Reference No:	2025/62/93287/W
Site Address:	19, Smithy Way, Lindley, Huddersfield, HD3 3ZD
Description:	Erection of single storey rear and side extension
Recommending Officer:	Morgan Braithwaite

DECISION – Conditional Full Permission

OFFICER REPORT

SHEET
Proposed Sheet 2

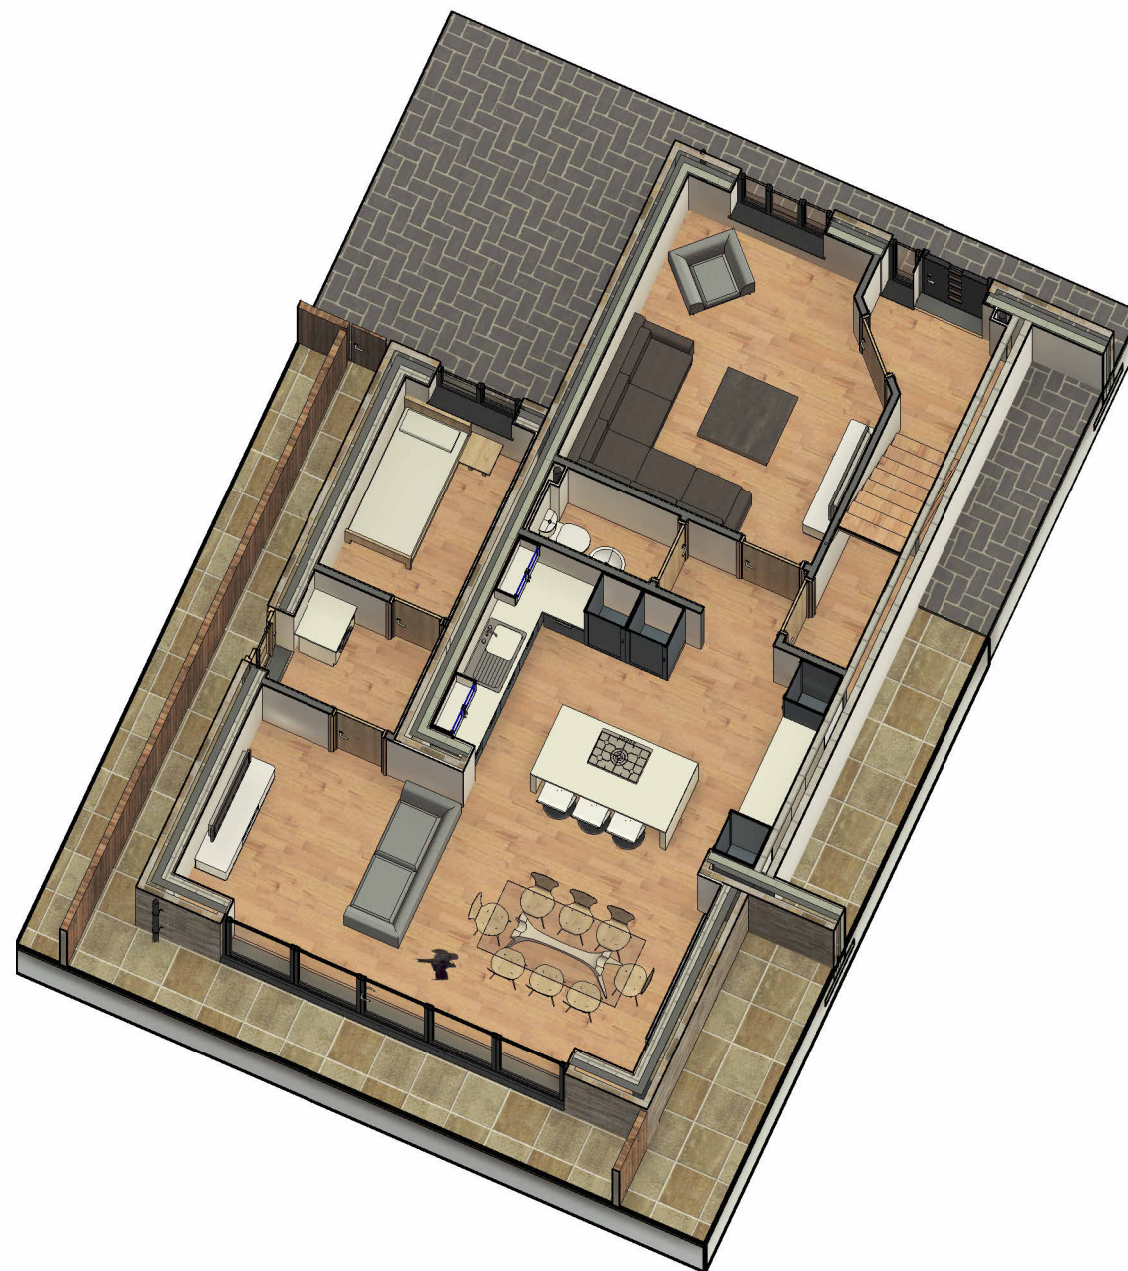
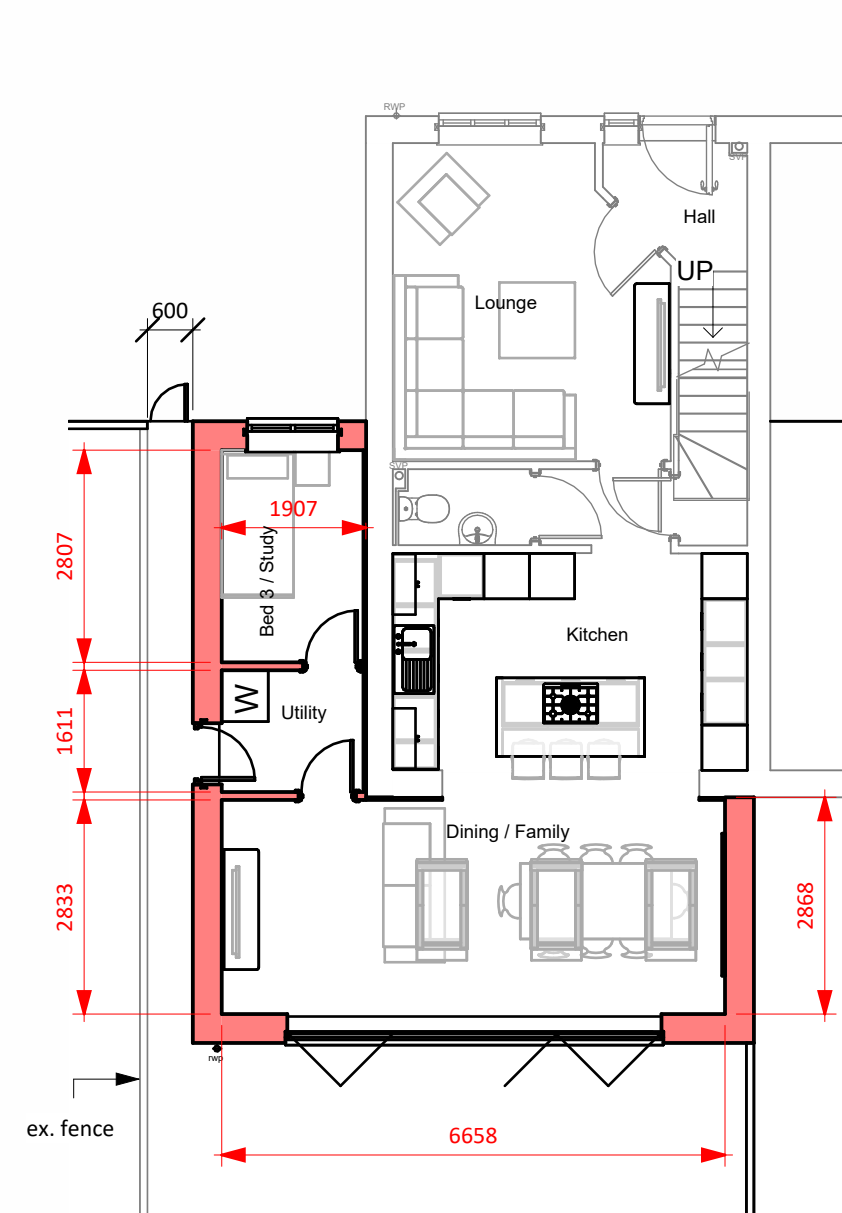
- Boundary concerns and inaccuracies in the submitted plans – The submitted plans suggest that the existing boundary treatment is to be removed and replaced with the extension wall.
Officer response: This concern was discussed with the agent, who explained that the boundary fence is not to be removed. Amended plans have been submitted to show the boundary fence still in situ.

- Required one-metre gap
Officer Response: The amended plans show the proposed rear extension to be set in from the boundary, however this would be by less than 0.5m. Whilst the Council's House Extensions and Alterations SPD advises that extensions should be set in by 1.0m from the shared boundary, the potential impact of the proposal in this case as a result of the proposed arrangement is not considered to be so significant to warrant refusal of the application for the reasons already set out above.
